PROJECT: Waterville Street Condominium Building C

# Memorandum

**Re:** Parking Garage Ventilation

**RE:** Waterville Street

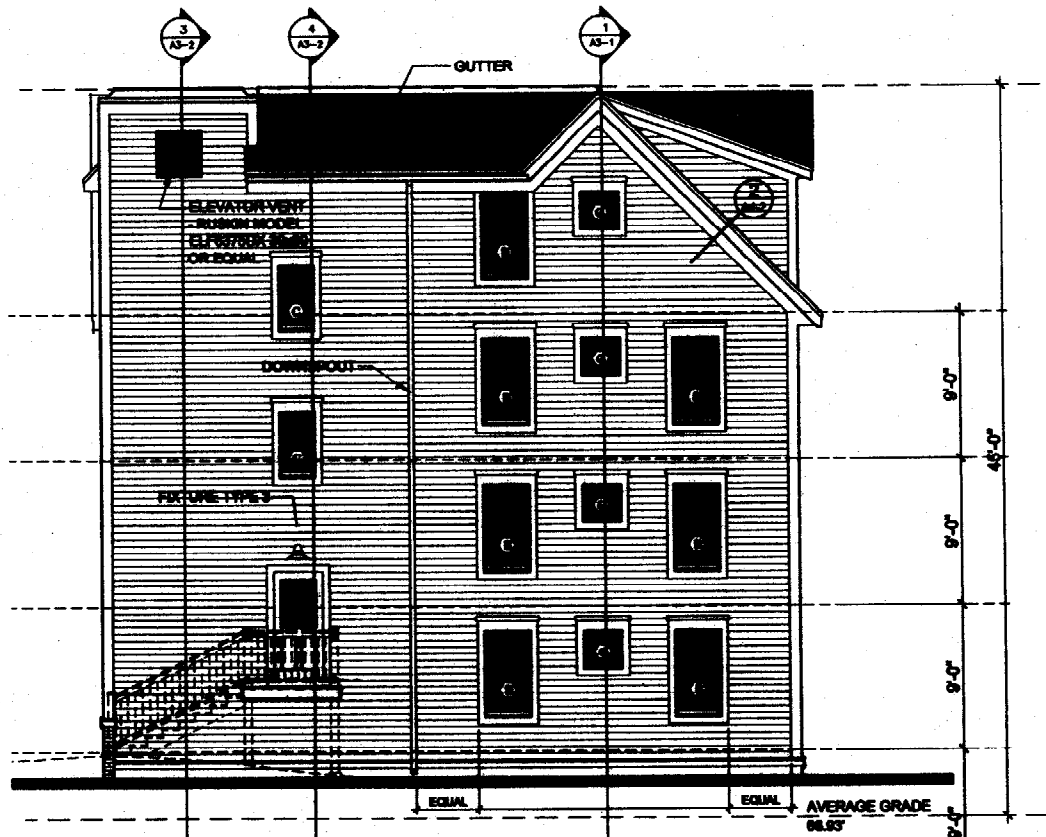
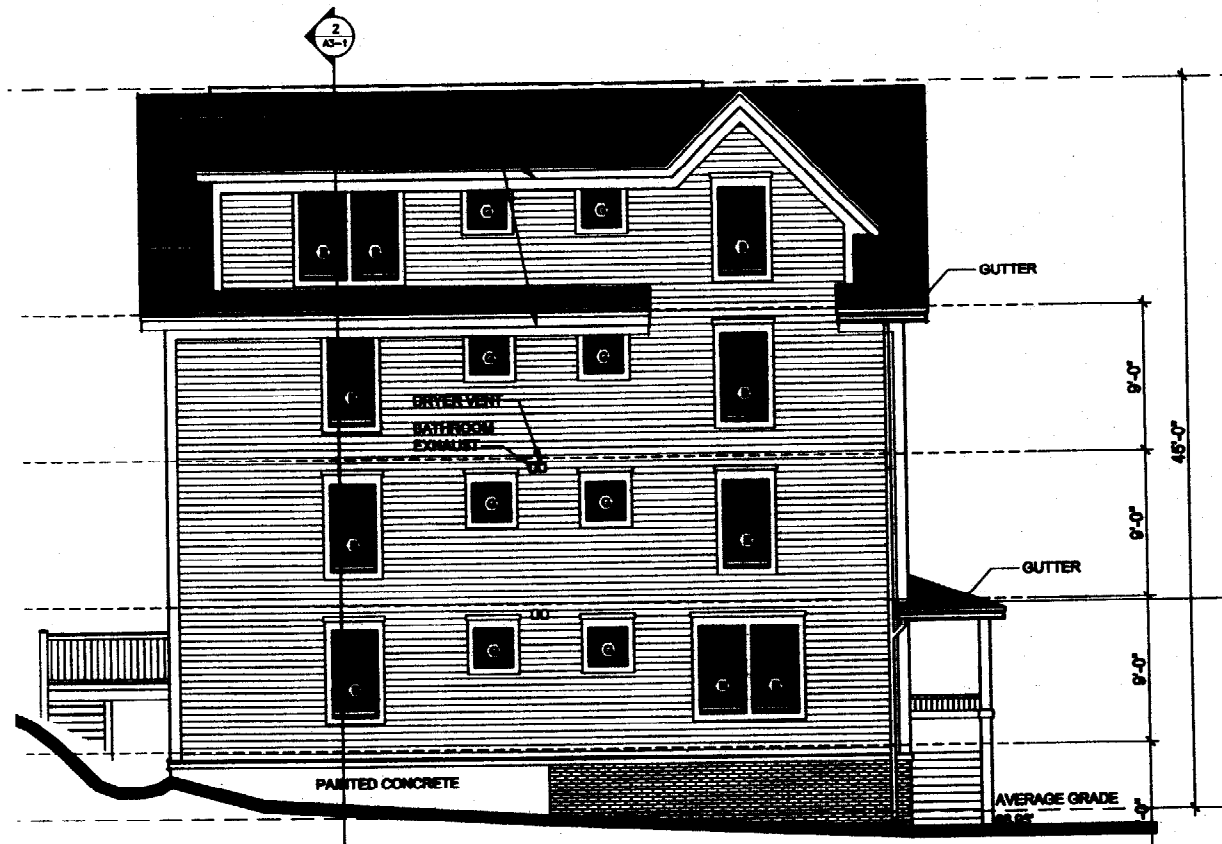
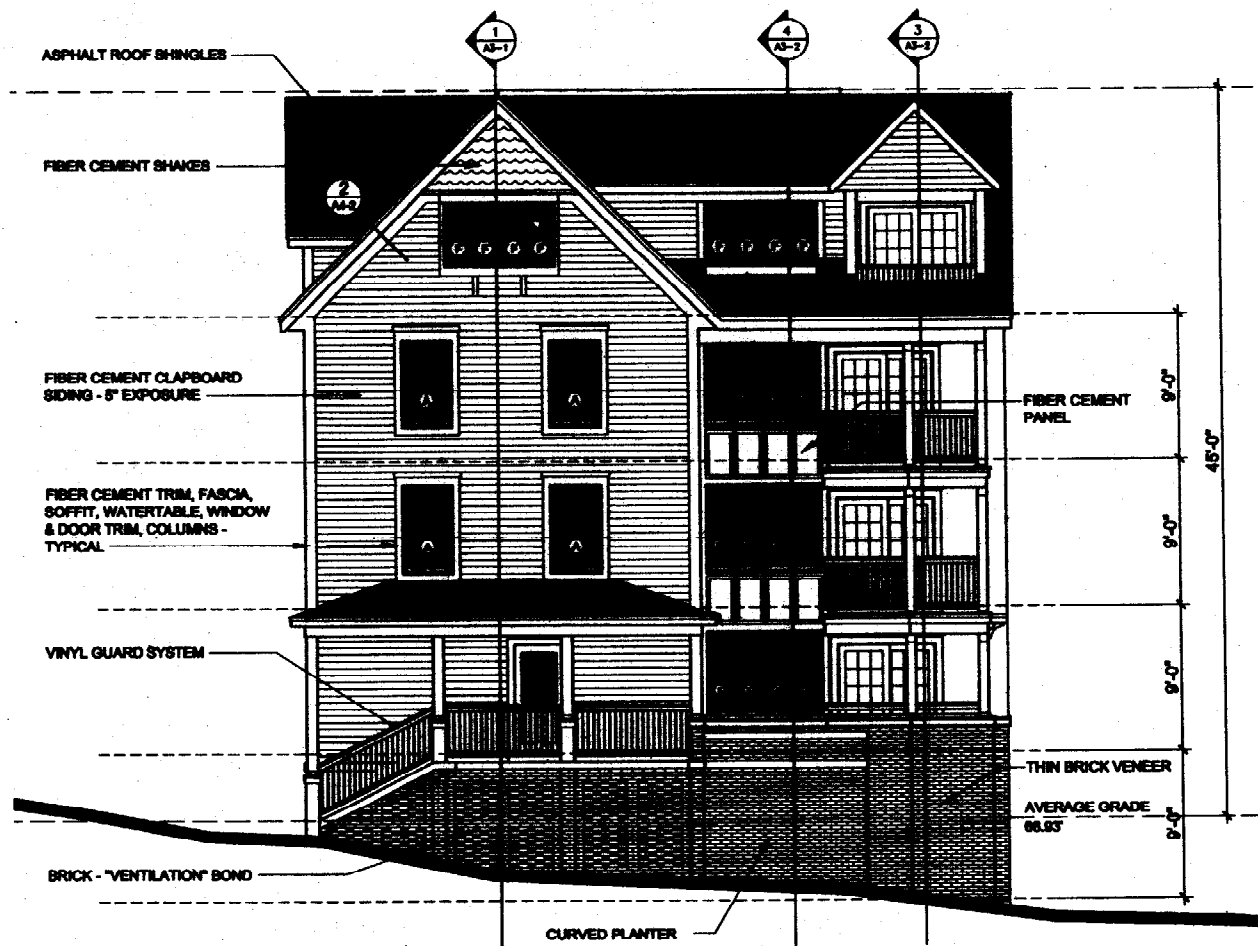
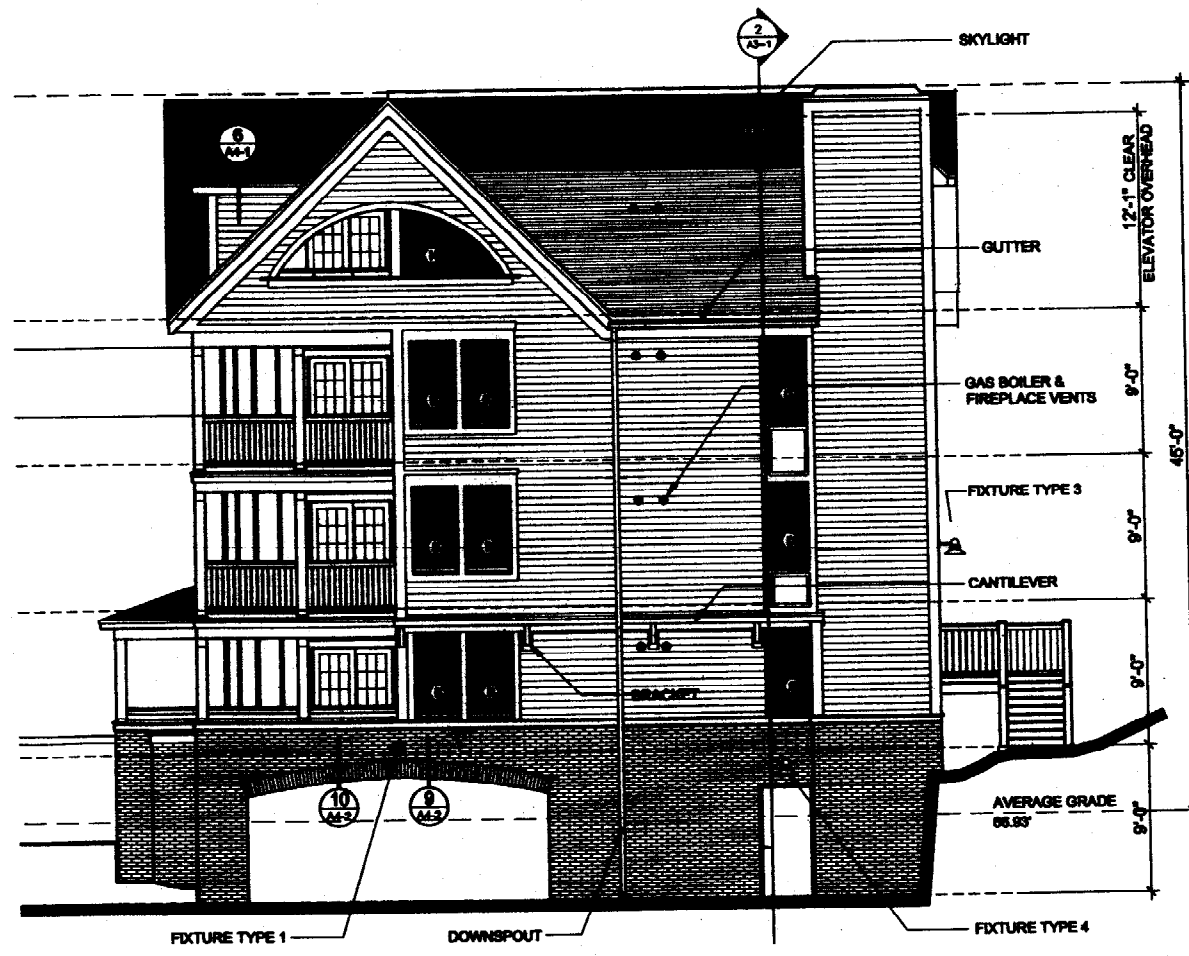
Where Mr. Whitney refers to locating the CO detector above the door to the "Utility" Room, he is actually referring to the room identified on the plans as the Maintenance Room (such that the CO detector remains located as shown on the E1-1 plan).

5. Provide CO detector and operate fan from at detection of CO level of 25 PPM or higher. Locate CO detector above door to utility room.

ROOF FRAMING PLAN
1/2" = 1'-0"

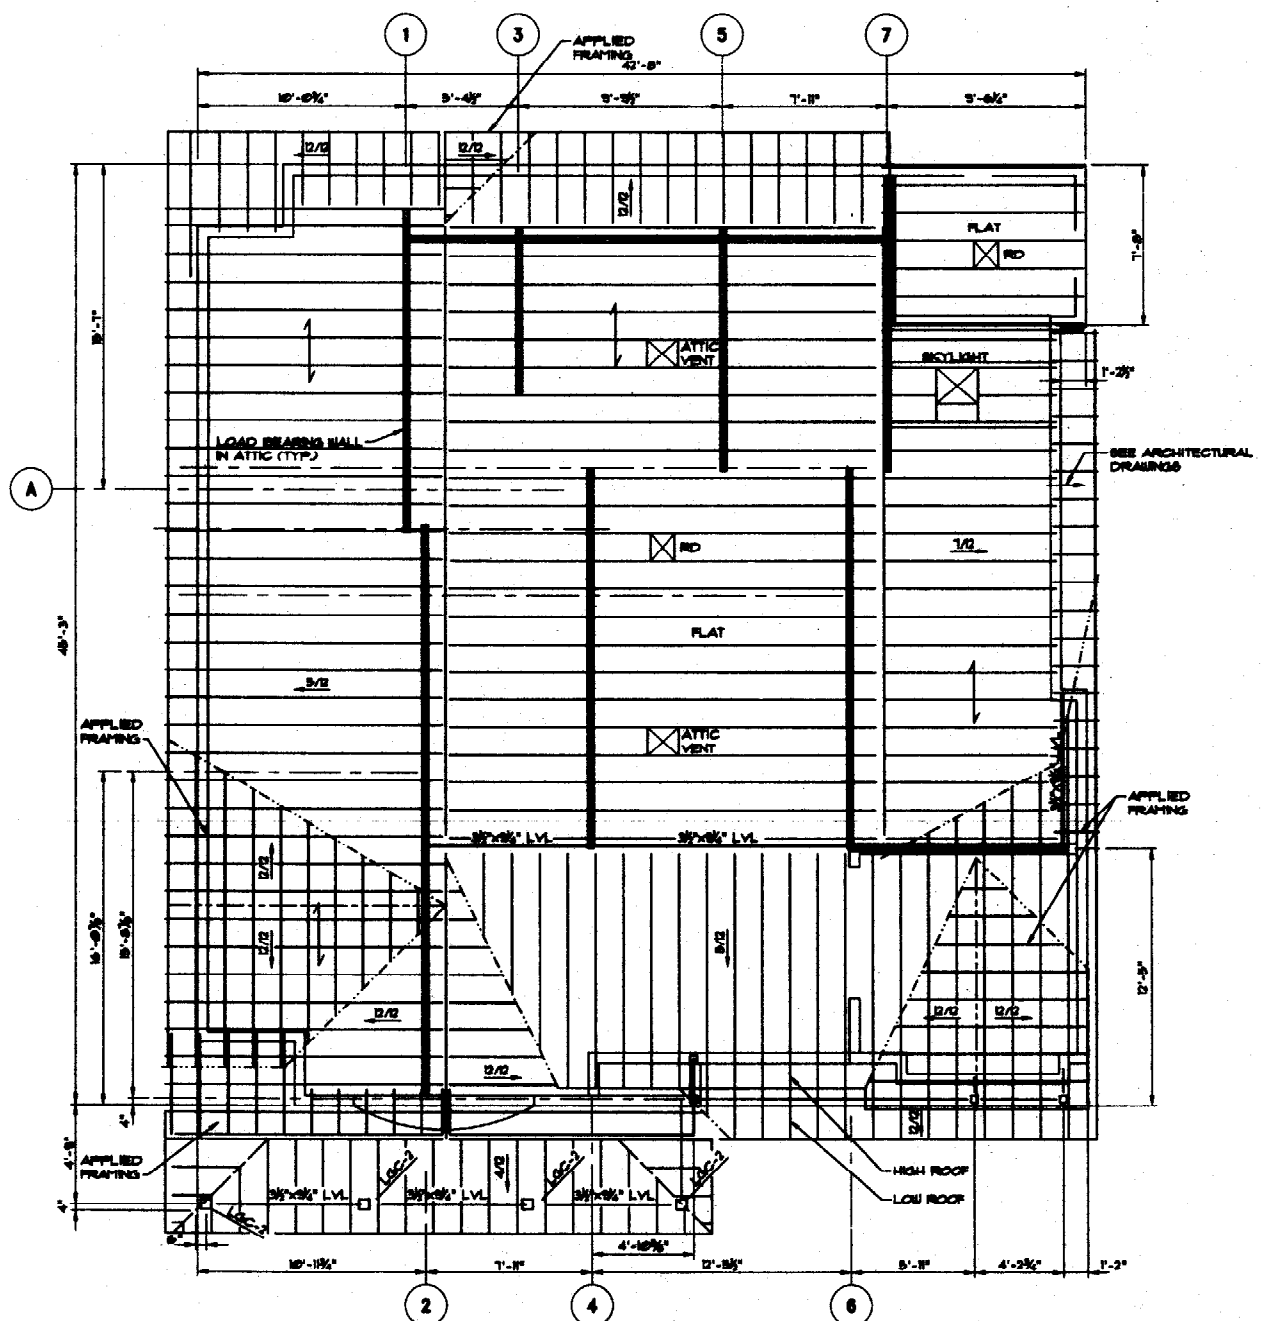
5. The design is in accordance with section 7.3 of ASCE 7.
6. My calculations have been done for a roof thermal factor of 1.1 but the drawings indicate it to be 1.0. I will revise drawing S1 to include this correction. The ground snow load for this area in 1989 BOCA is 50 not 60 psf, I will correct this also.
7. The C<sub>s</sub> factor for roof slope is 1.0 for this project. The sloped roof snow load is the same as the flat roof snow load.
8. The seismic soil profile type is S<sub>1</sub>.
9. The basic structural system is a load bearing wall system. The seismic resisting system is light frame walls with shear panels.
10. The seismic analysis procedure is the equivalent lateral force procedure per section 1610.4.
11. The note regarding nailing on S6 will be revised to read "1999 BOCA".
12. The roof framing is 2x10 rafters at 16" oc as per note 1 on the roof framing plan.
